CITY OF ALBUQUERQUE

October 10, 2023

Re: Roadrunner Veterinary Hospital
5971 Jefferson St. NE
Traffic Circulation Layout
Architect's Stamp 08-16-23 (E17-D078)

A3 TRAFFIC CIRCULATION LAYOUT

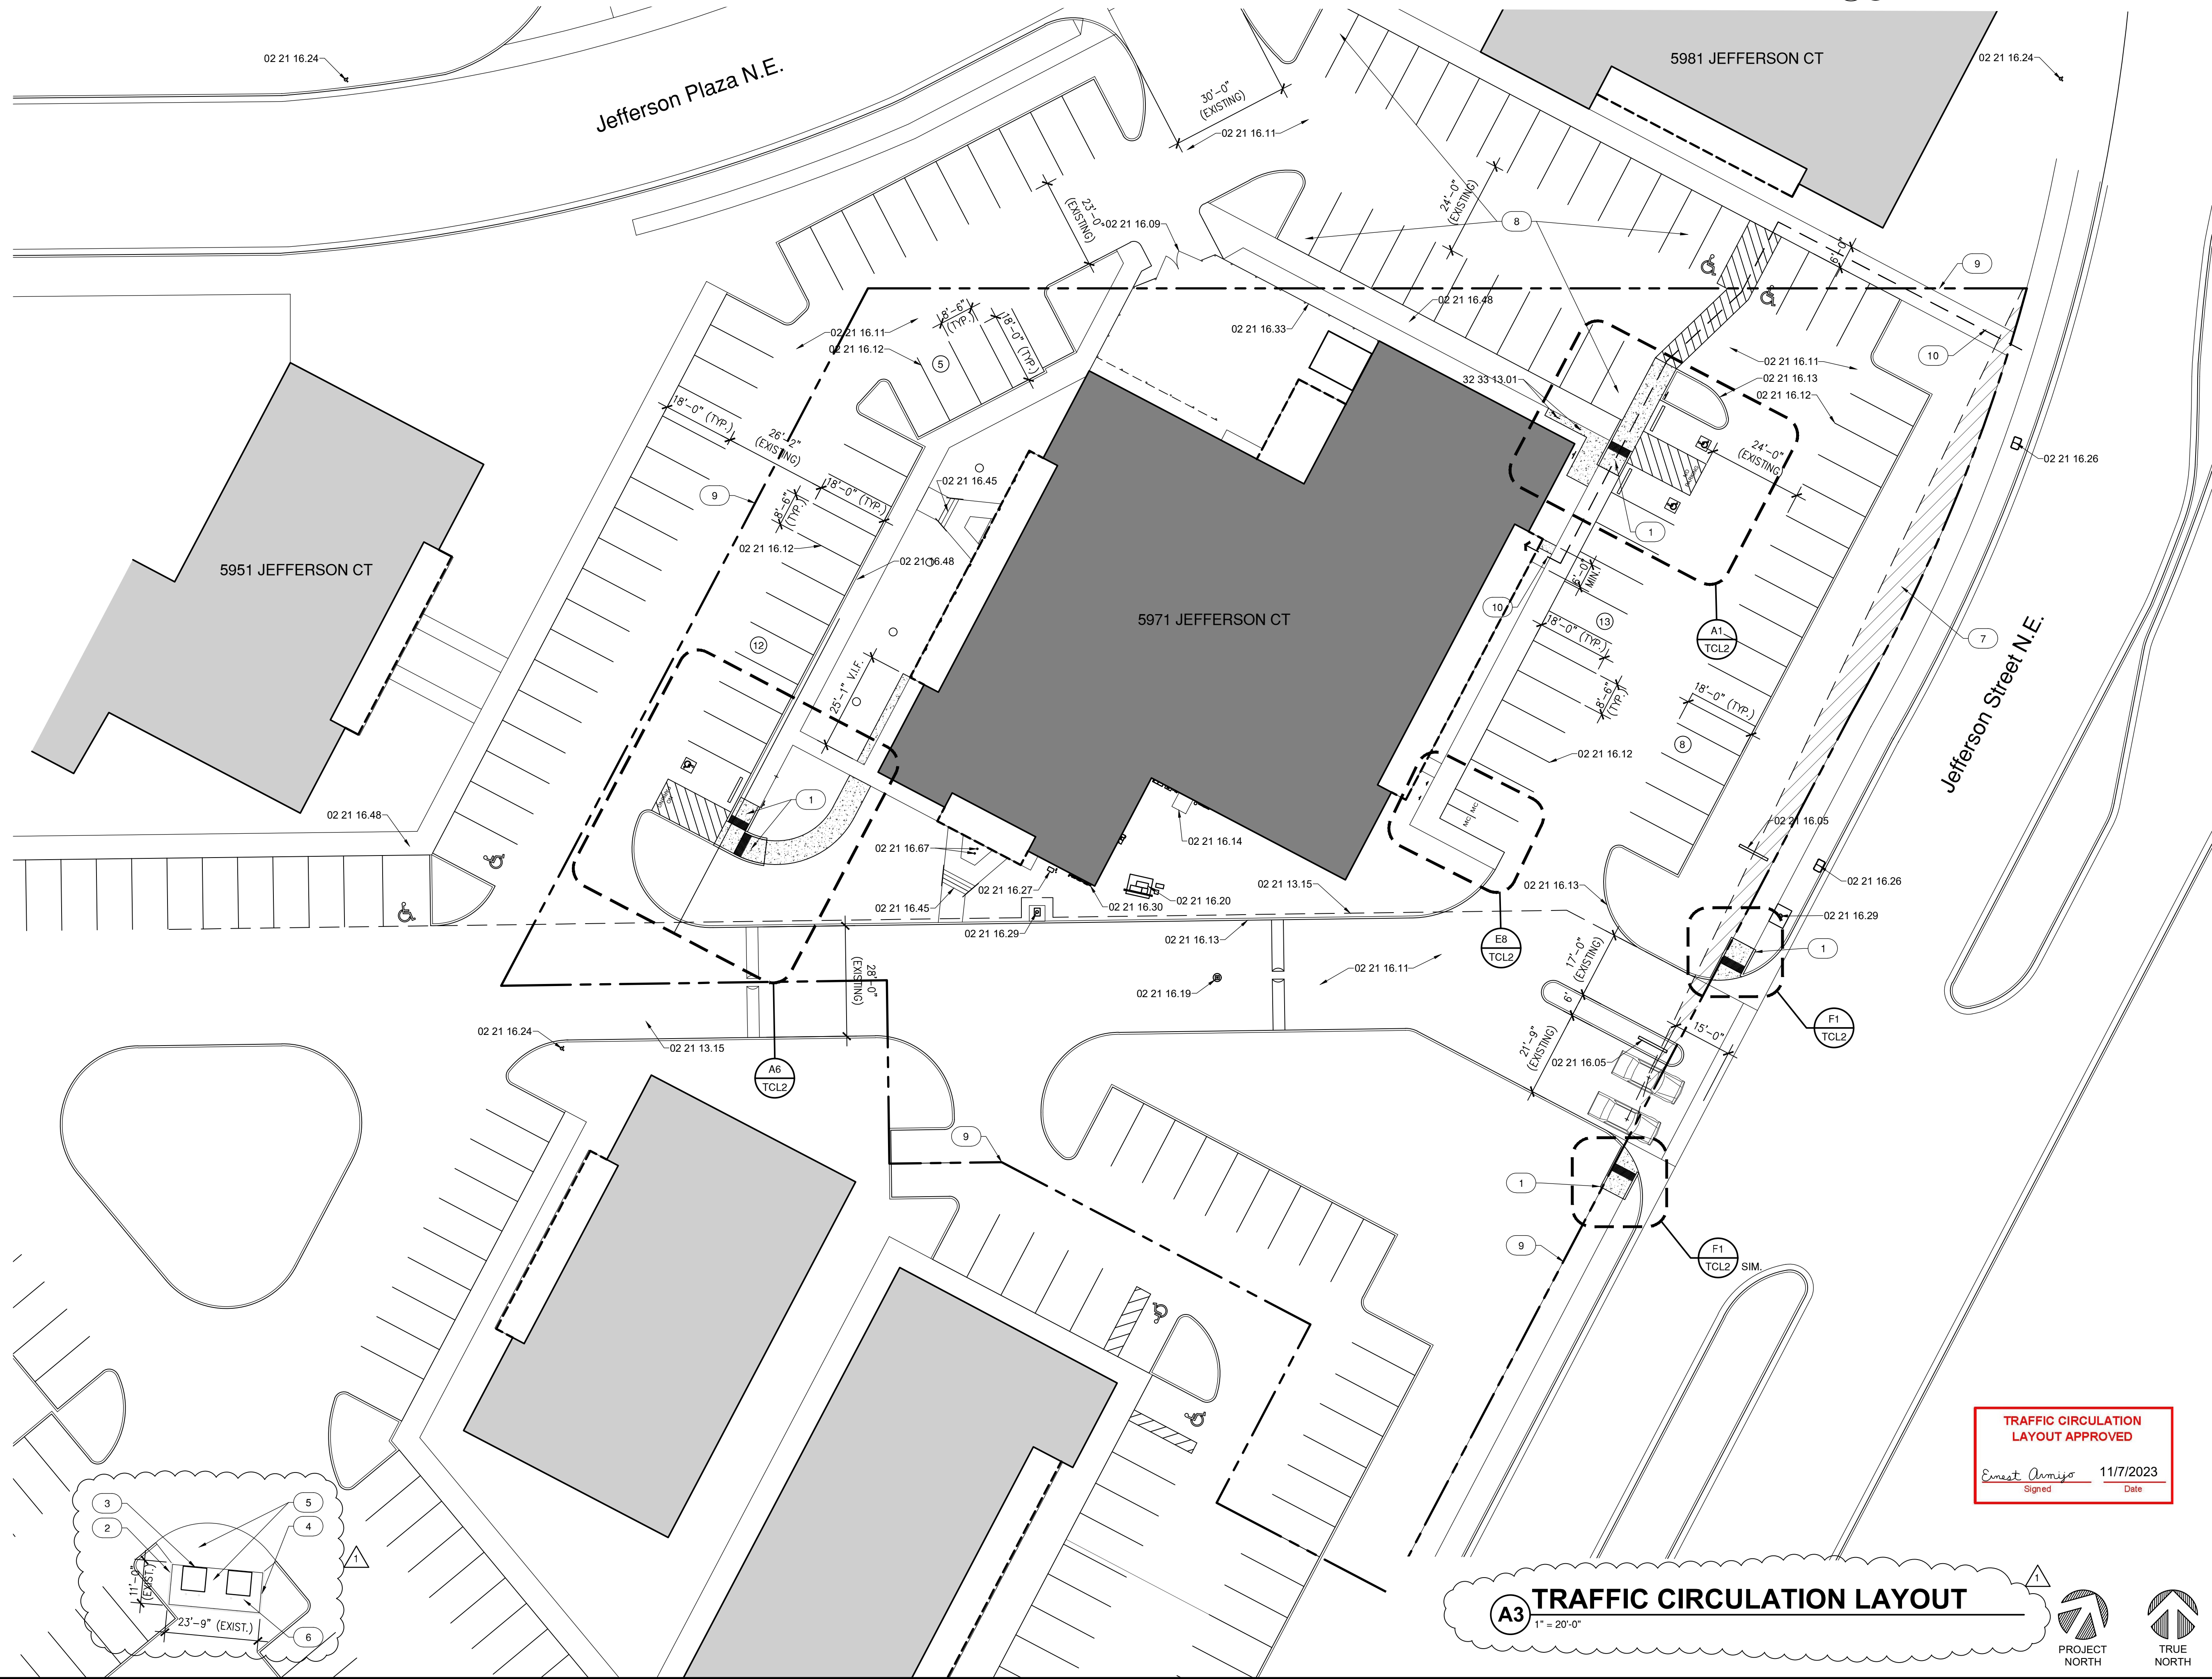
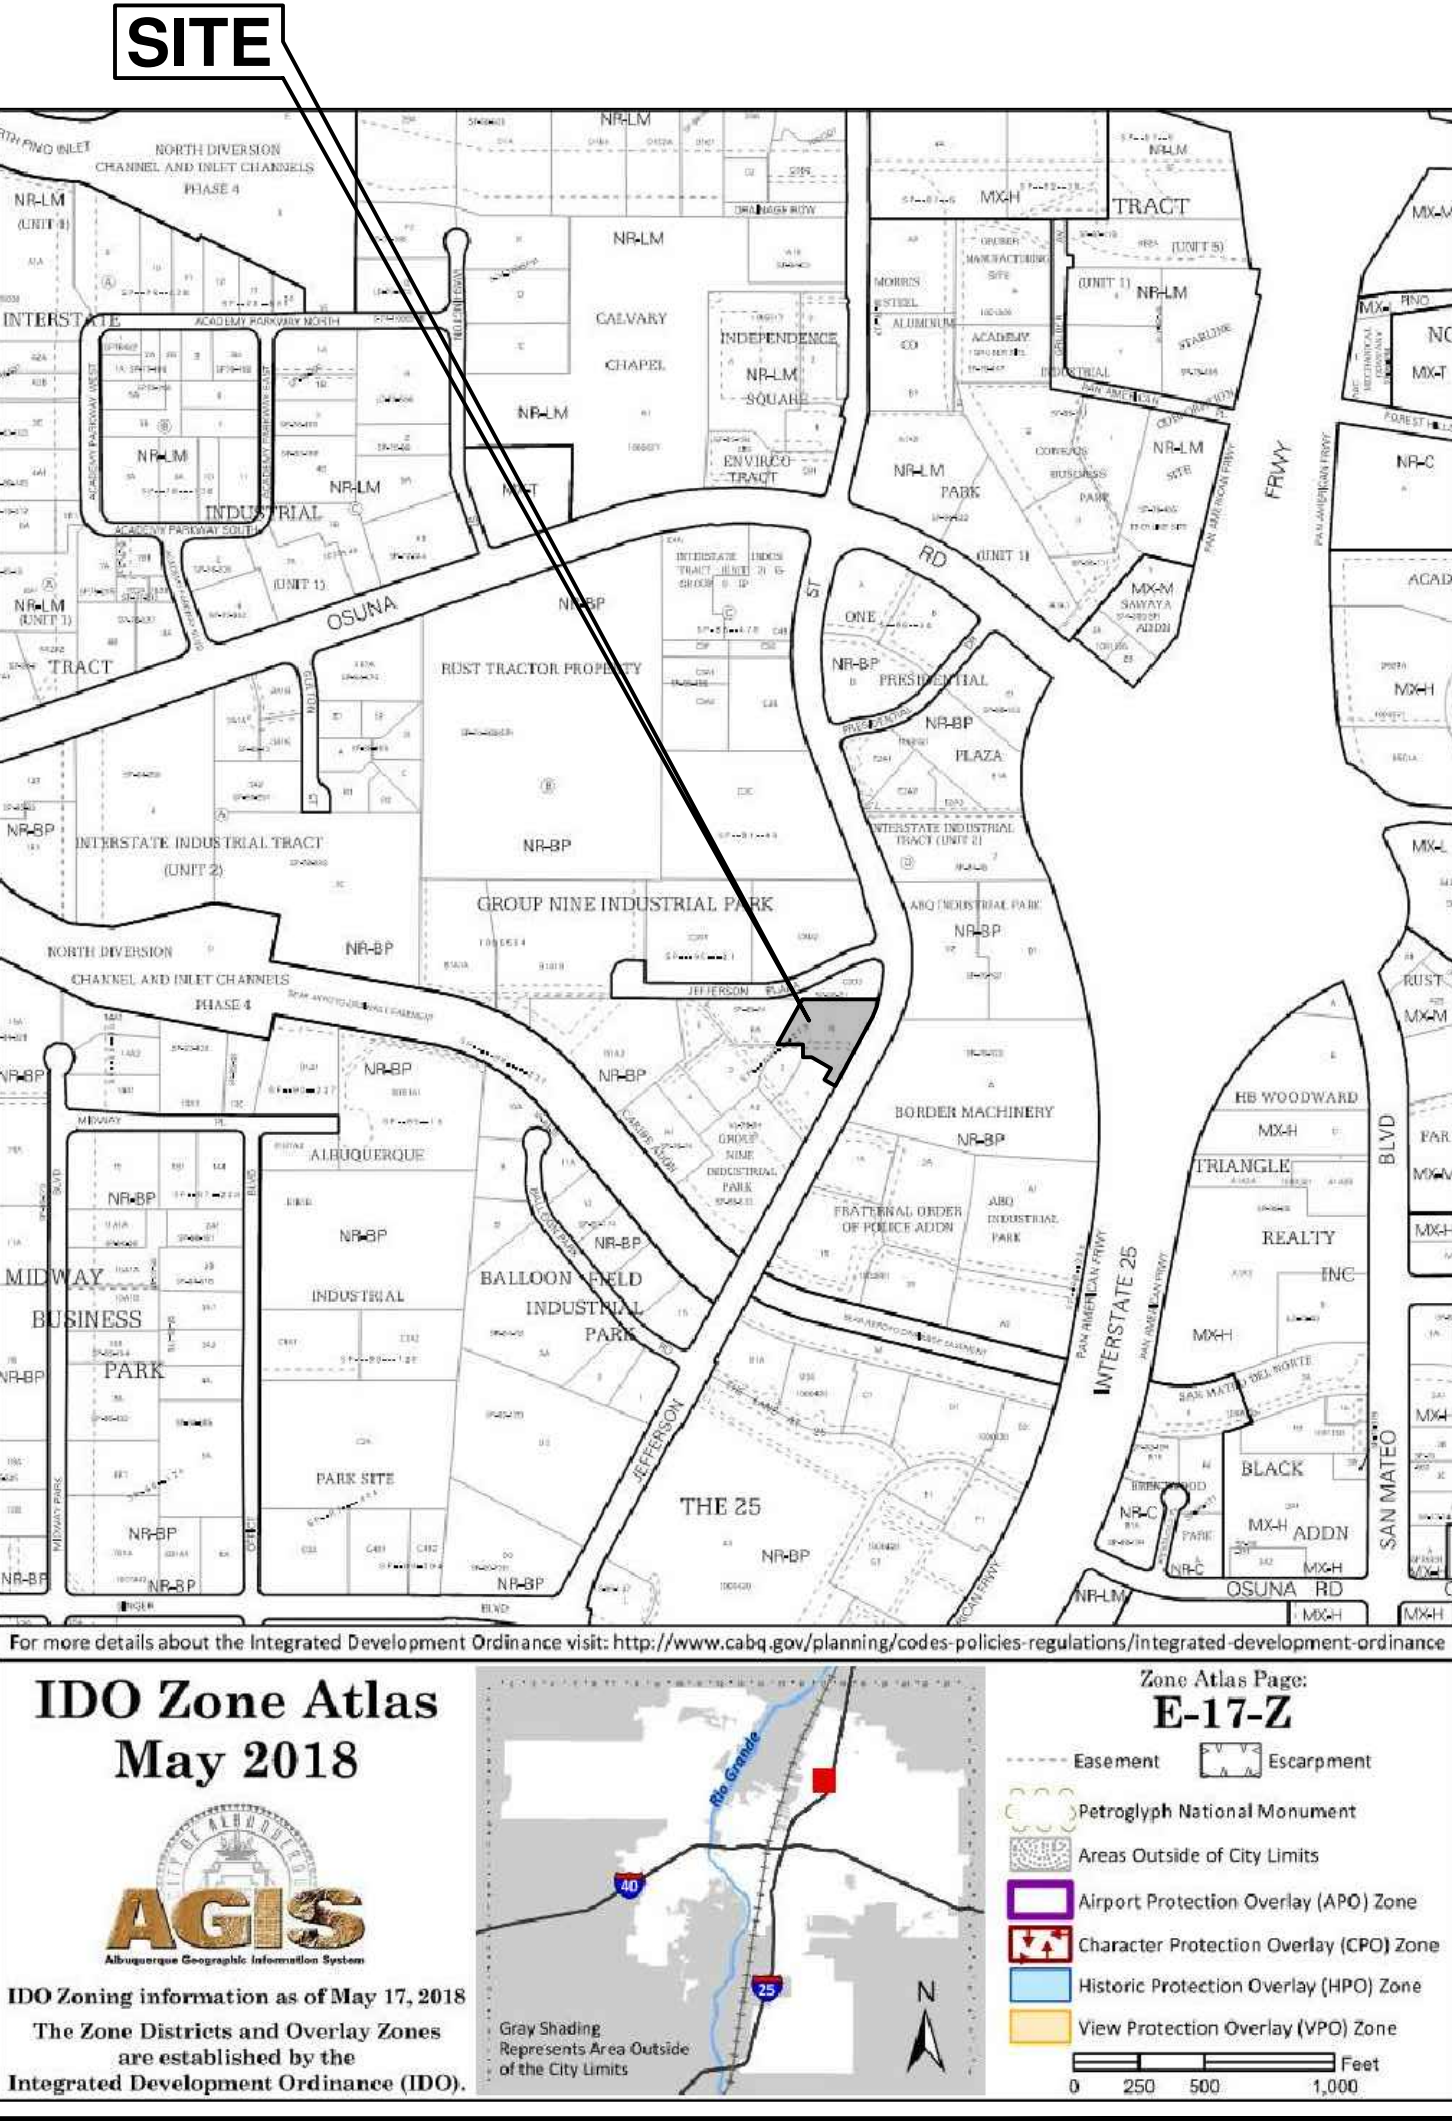
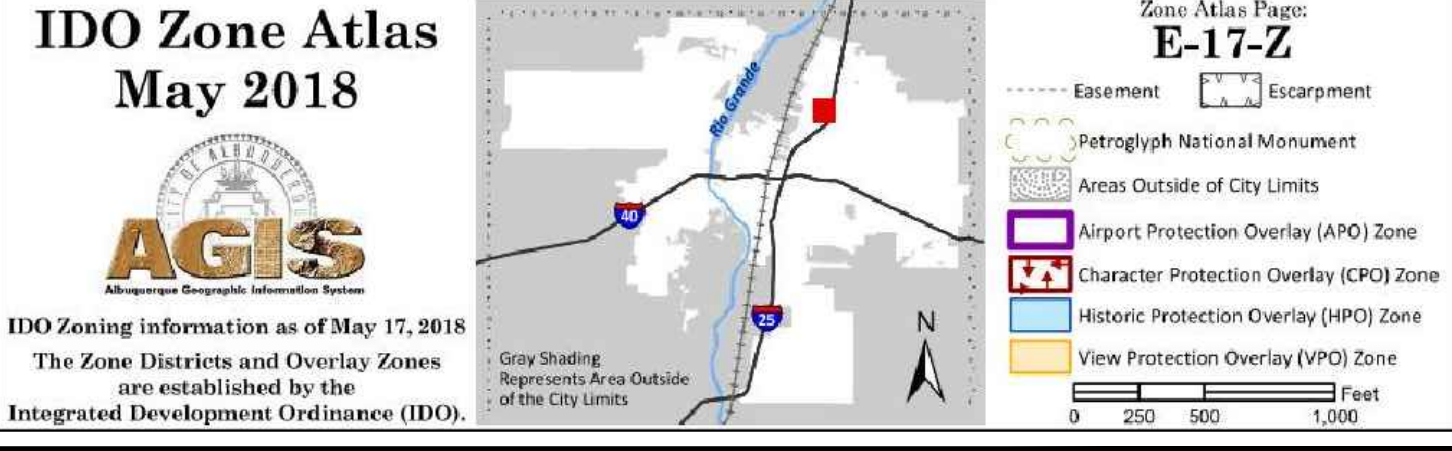
1. List the number of Motorcycle and Bicycle parking spaces required by the IDO.
2. Identify all existing access easements and rights of way width dimensions.
3. Show on the site plan the existing site accesses width.
4. Due to show the property line in the middle of the site, please provide approved plat showing shares accesses and parking agreement.
5. Please list the width and length for all existing and proposed parking spaces. Some dimensions are not shown.
6. The minimum parking stall dimensions are:

7. The ADA accessible spaces must include an access aisle. Van accessible aisles should be 8ft wide; all others should be 5ft wide.
8. **All ADA signage** must be updated to the current standard. The ADA accessible parking sign must have the required language per 66-7-352.4C NMSA 1978 "**Violators Are Subject to a Fine and/or Towing.**" Please call out detail and location of signs.
9. **All the ADA access aisles** shall have the words "**NO PARKING**" in capital letters, each of which shall be at least one foot high and at least two inches wide, placed at the rear of the parking space so as to be close to where an adjacent vehicle's rear tire would be placed. (66-1-4.1. B NMSA 1978)

10. ADA curb ramps at the site accesses must be updated to current standards and have truncated domes installed.
11. All the interior existing ADA curb ramps must be updated to current standards and have truncated domes installed.

12. Motorcycle parking spaces shall be designated by its own conspicuously posted upright sign, either free-standing or wall mounted per the zoning code.

13. The pavement marking "MC" should be shown in the opposite direction for motorcycles entering the parking space.
14. All bicycle racks shall be designed according to the following guidelines:

18. Show all drive aisle widths and radii. Some dimensions are not shown.
19. The minimum drive aisle dimensions are shown below

20. Per the IDO, a 6 ft. wide ADA accessible pedestrian pathway is required from the public sidewalk to the building entrances. Please clearly show this pathway and provide details.
21. Per DPM, a 6 ft. wide ADA accessible pedestrian pathway is required from the ADA parking stall access aisles to the building entrances. Please clearly show this pathway and provide details.
22. ADA accessible pedestrian pathway should not be placed behind parking space or adjacent to a vehicular way. Vehicle and pedestrian/wheel chair conflicts should be avoided as much as possible.

23. Provide a copy of Fire Marshal and Solid Waste approval.
24. It is not apparent what type of pavement surface is being proposed. A hard driving surface will be required as part of this proposed project for parking area and drive aisles.

25. Show the Intersection clear sight triangle and add the following note to the plan:
"Landscaping and signage will not interfere with clear sight requirements. Therefore, signs, walls, trees, and shrubbery between 3 and 8 feet tall (as measured from the gutter pan) will not be acceptable in the clear sight triangle.

26. Please specify the City Standard Drawing Number when applicable.
27. Add a note stating "All broken or cracked sidewalk must be replaced with sidewalk and curb & gutter." A build note must be provided referring to the appropriate City Standard drawing.
